**KIRKLEES METROPOLITAN COUNCIL
INVESTMENT & REGENERATION SERVICE**

**DELEGATED DECISION FOR APPLICATION FOR CERTIFICATE OF
LAWFUL DEVELOPMENT**

Reference no.: 2025/CL/92360/W

Description: Certificate of lawfulness for proposed loft
conversion with rooflights to rear elevation and associated alterations

Rear Elevation
As Proposed

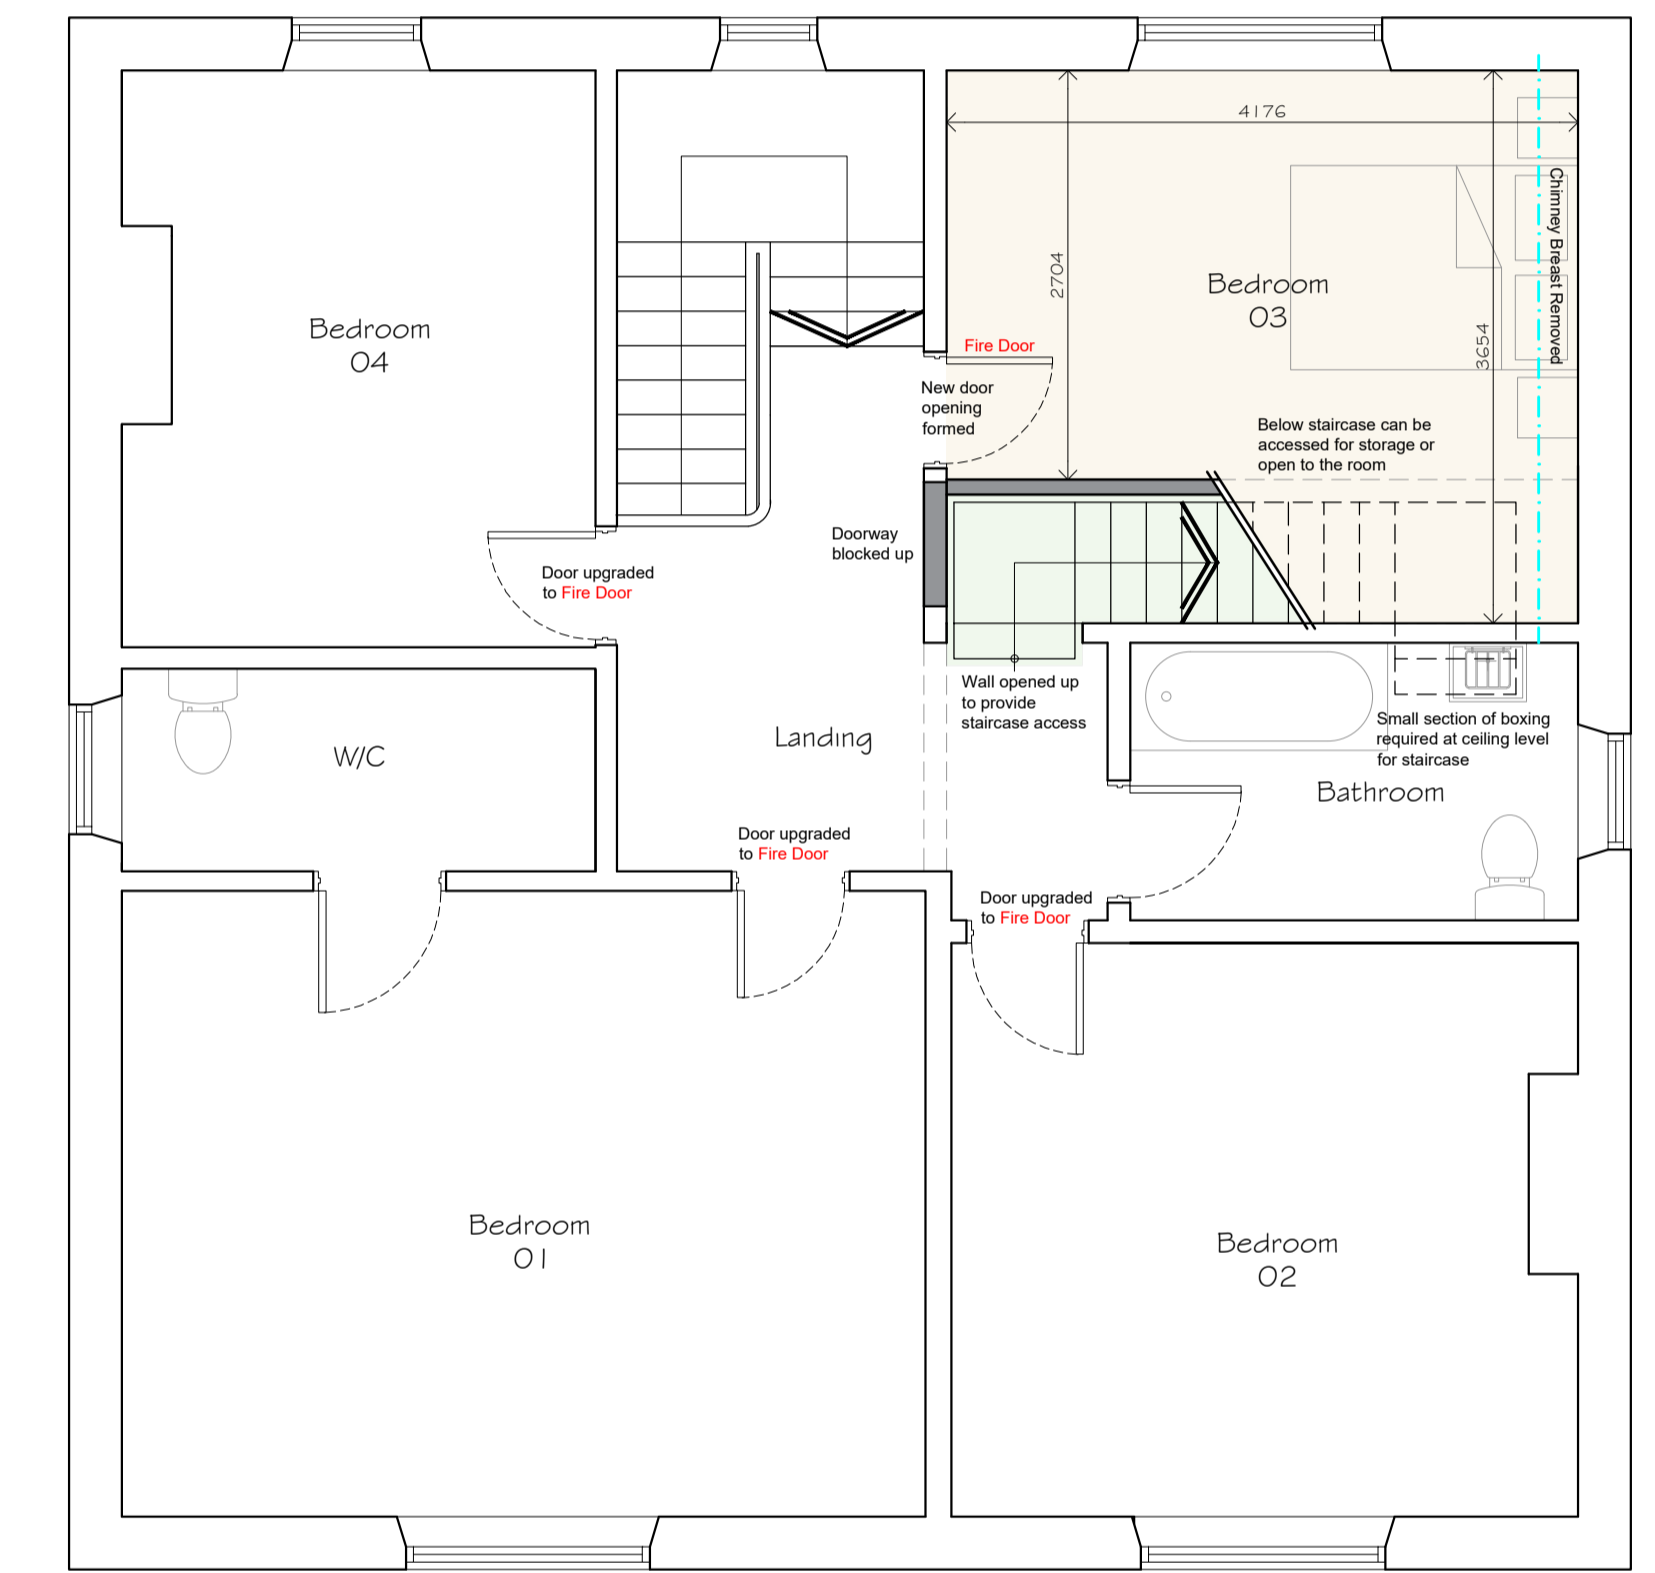
Comment: *The submitted plans indicate that the alterations would protrude no more than 0.15 metres beyond the plane of the roof slope.*

Comment: *The highest part of the alteration would not be higher than the highest part of the original roof.*

Comment: *No openings are proposed within the roof slope forming a side elevation of the dwellinghouse.*
